I am writing as a parent of a child that attends Darlington Public School regarding the proposed development by the University of Sydney, MP 07_0158 – Abercrombie Street Precinct, Syd Uni. Darlington Public School is an inner city school servicing the suburbs of Chippendale, Darlington and parts of Redfern. The school is directly adjacent to the western border of the project.

Drawing title
BASEMENT FLOOR PLAN

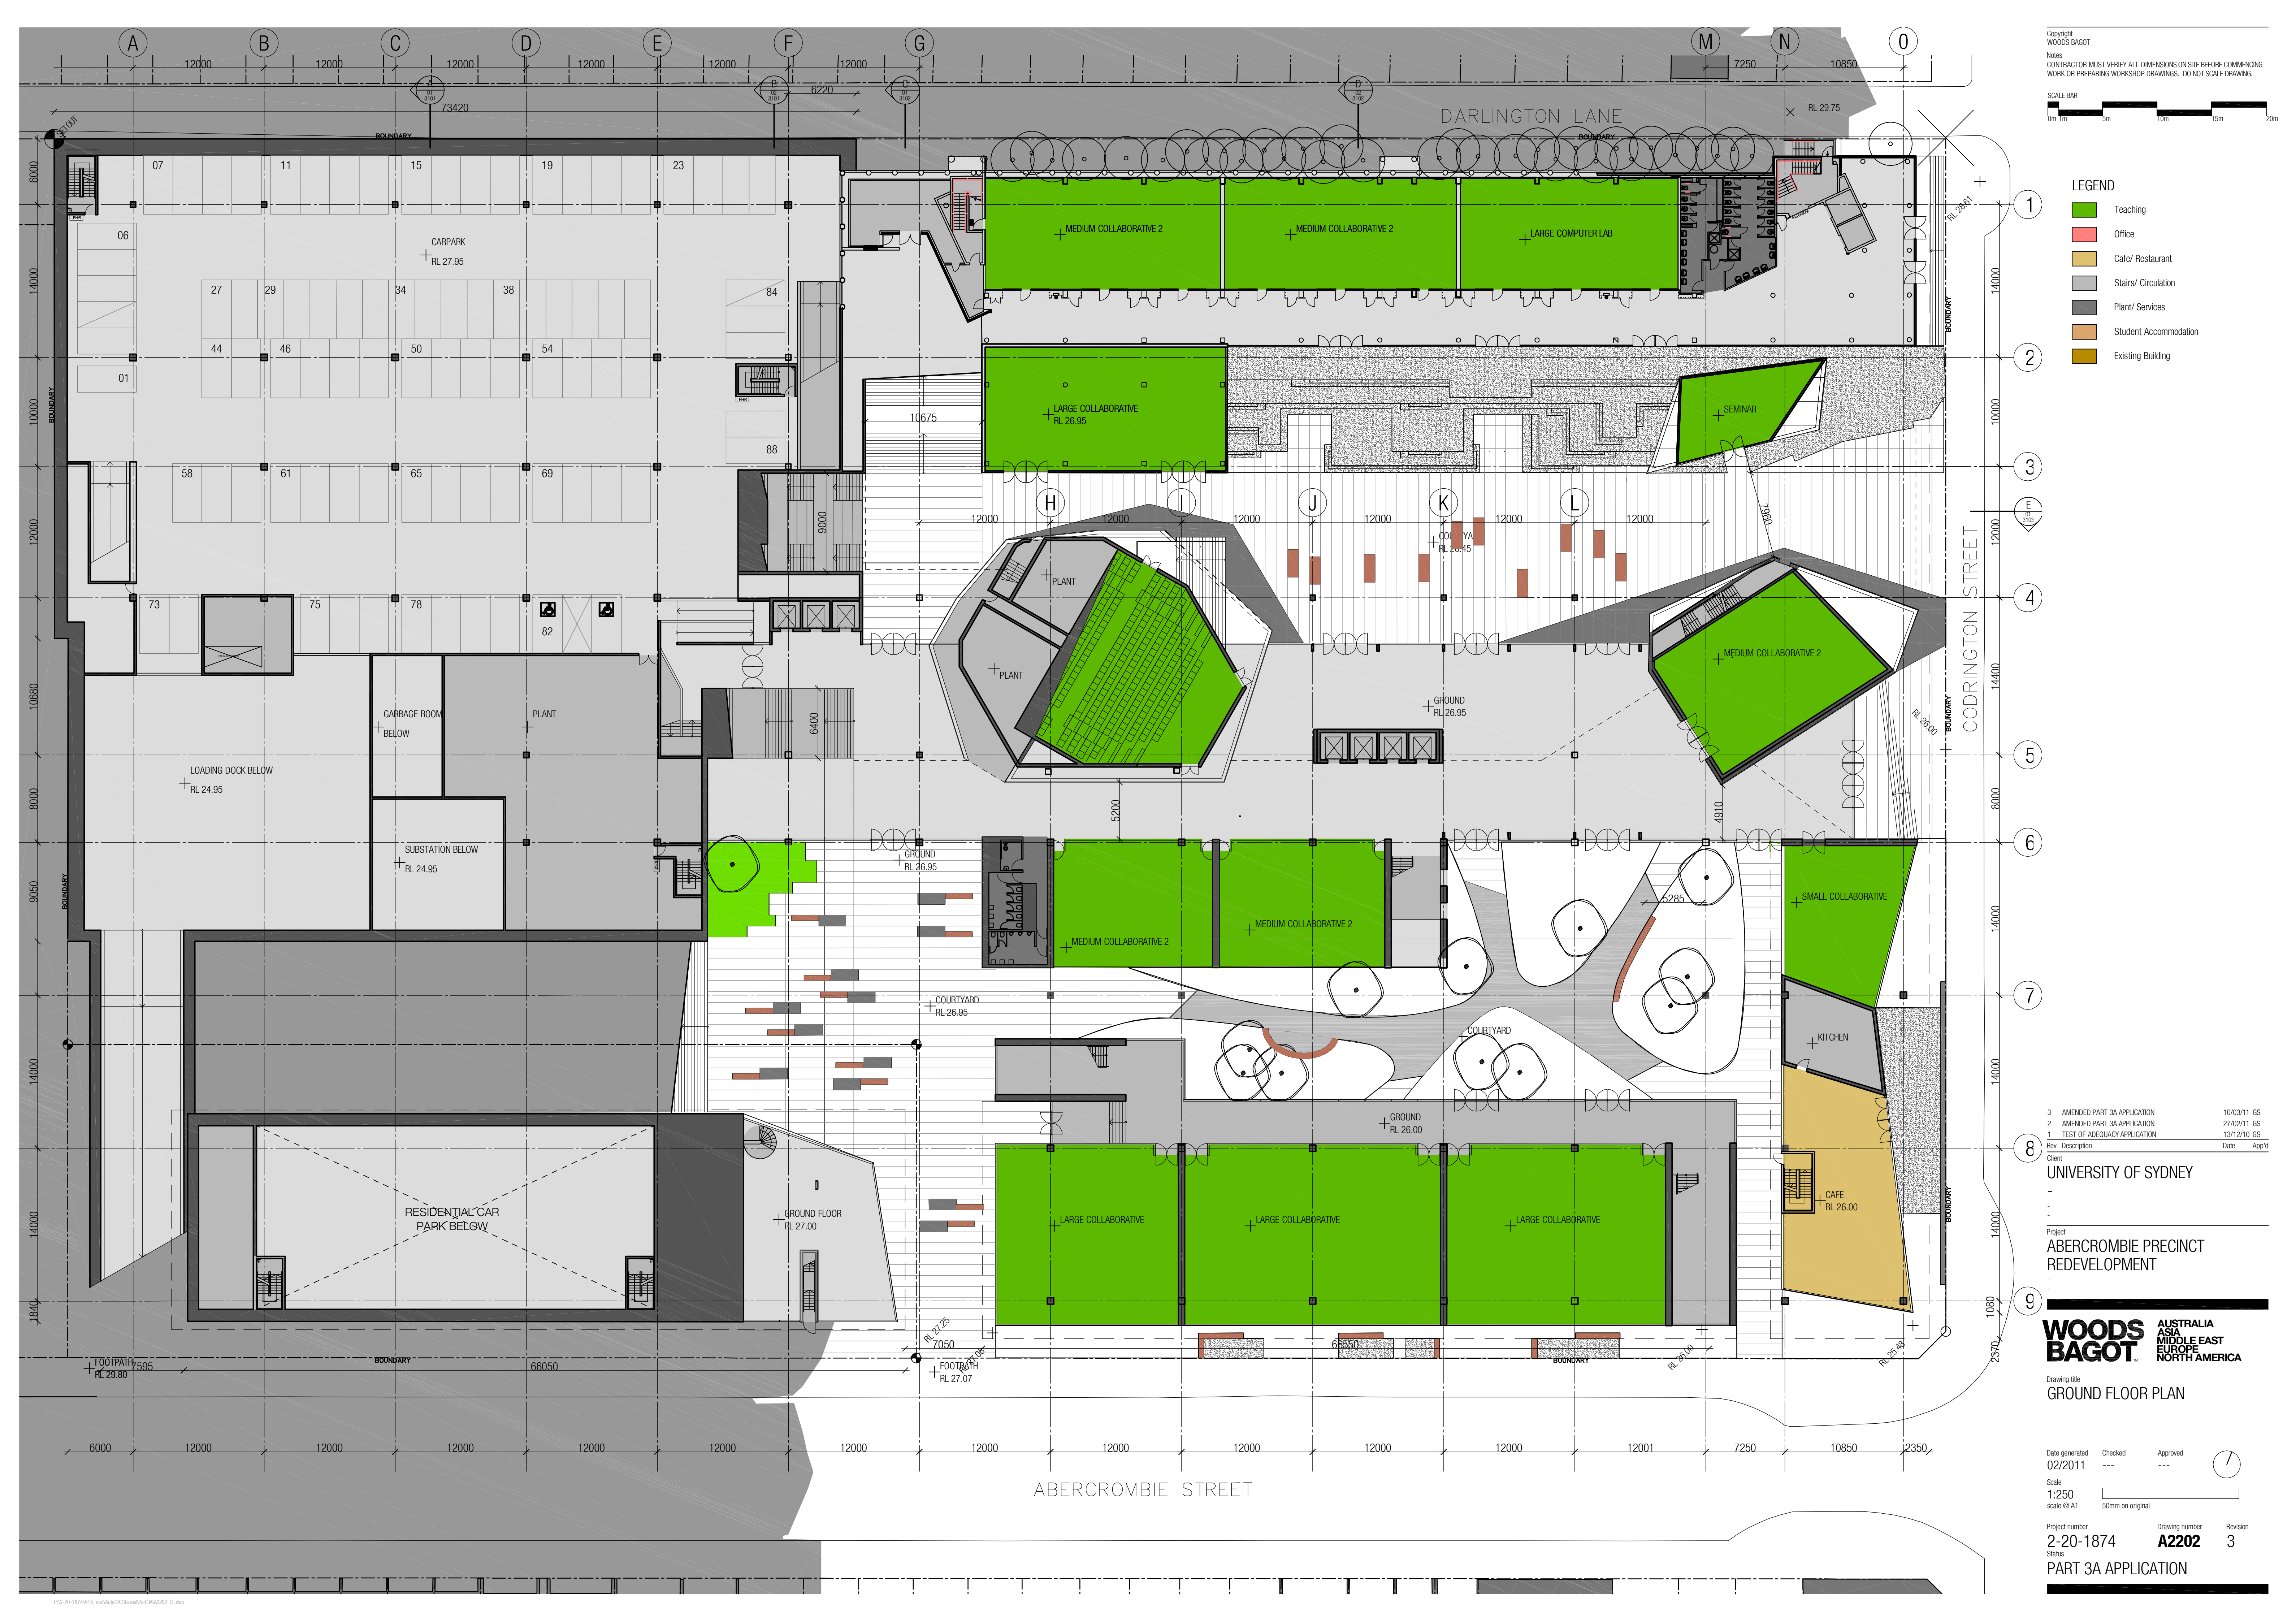
As per the current development plan, the proposal calls for an underground car park to be built for the student accommodation and University staff. The car park will accommodate 185 car spots, and its entrance will be on Abercrombie Street, at approximately the same point of the construction access.

The concerns raised above about the access point to the construction site are the same for this car park access point increasing the risk to school children's safety, in an area that has already been highlighted through the respective organisations (Council, Police, and RTA). The increased traffic flows and access point are an unacceptable risk to the children who attend the school. There is no justification for this level of risk to a school community, particularly as the University has another street frontage without school or residential issues (the University being the only stakeholder for Codrington Street) and an access street internal to project (Darlington Lane).

Drawing title
SHADOW DIAGRAMS - SUMMER
SOLSTICE - DECEMBER 22

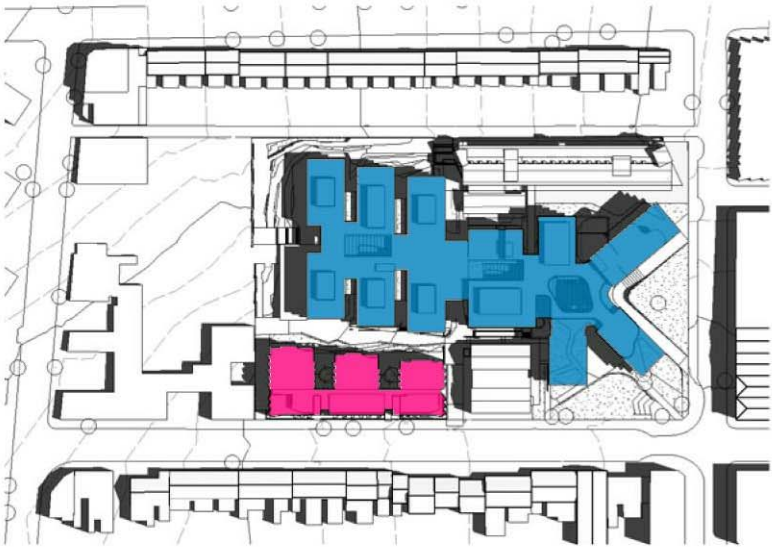
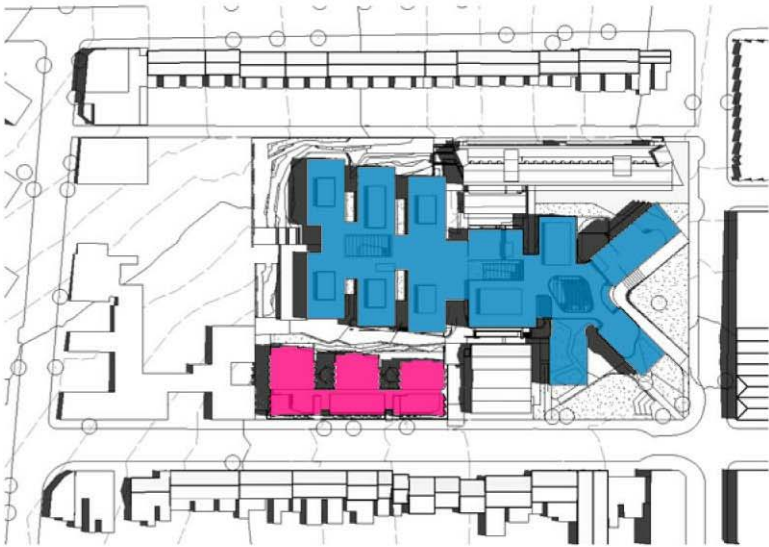
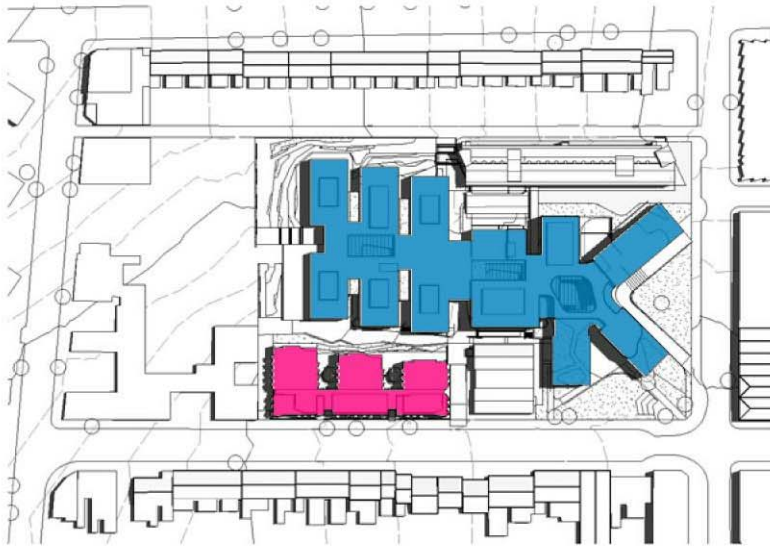
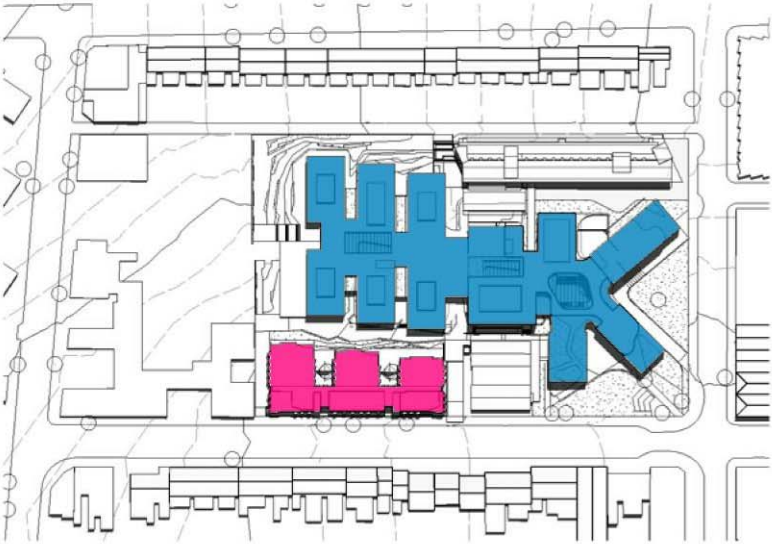
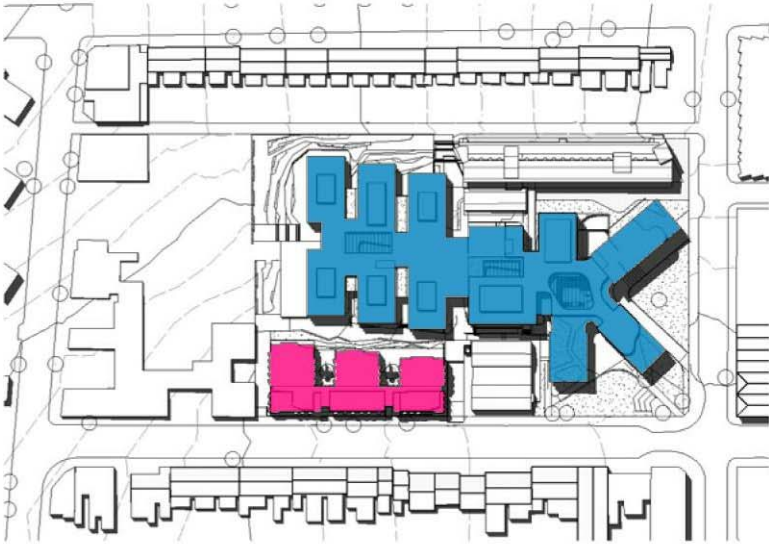
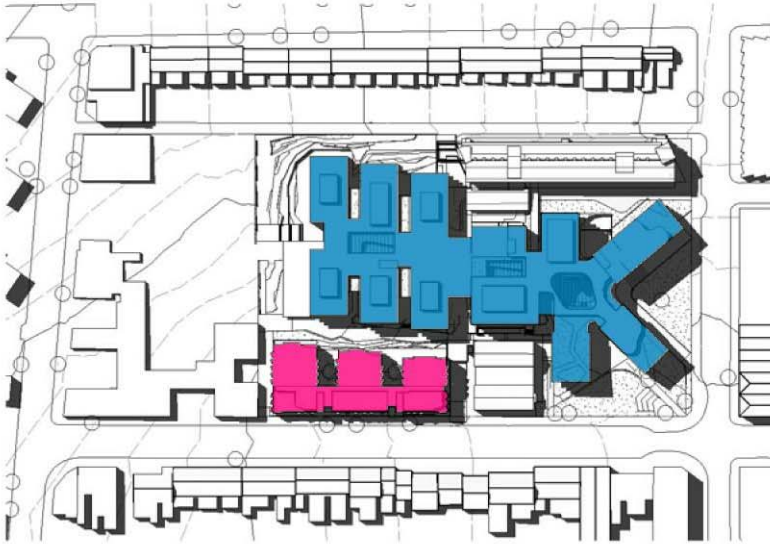
The new Business facility building will be seven stories high, and with its location in the North West corner of the school playground it will cause a large shadow effect over the majority of the playground.

What consideration has been given to this impact, and the requirement for natural light for the play areas, making it a suitable area to play?
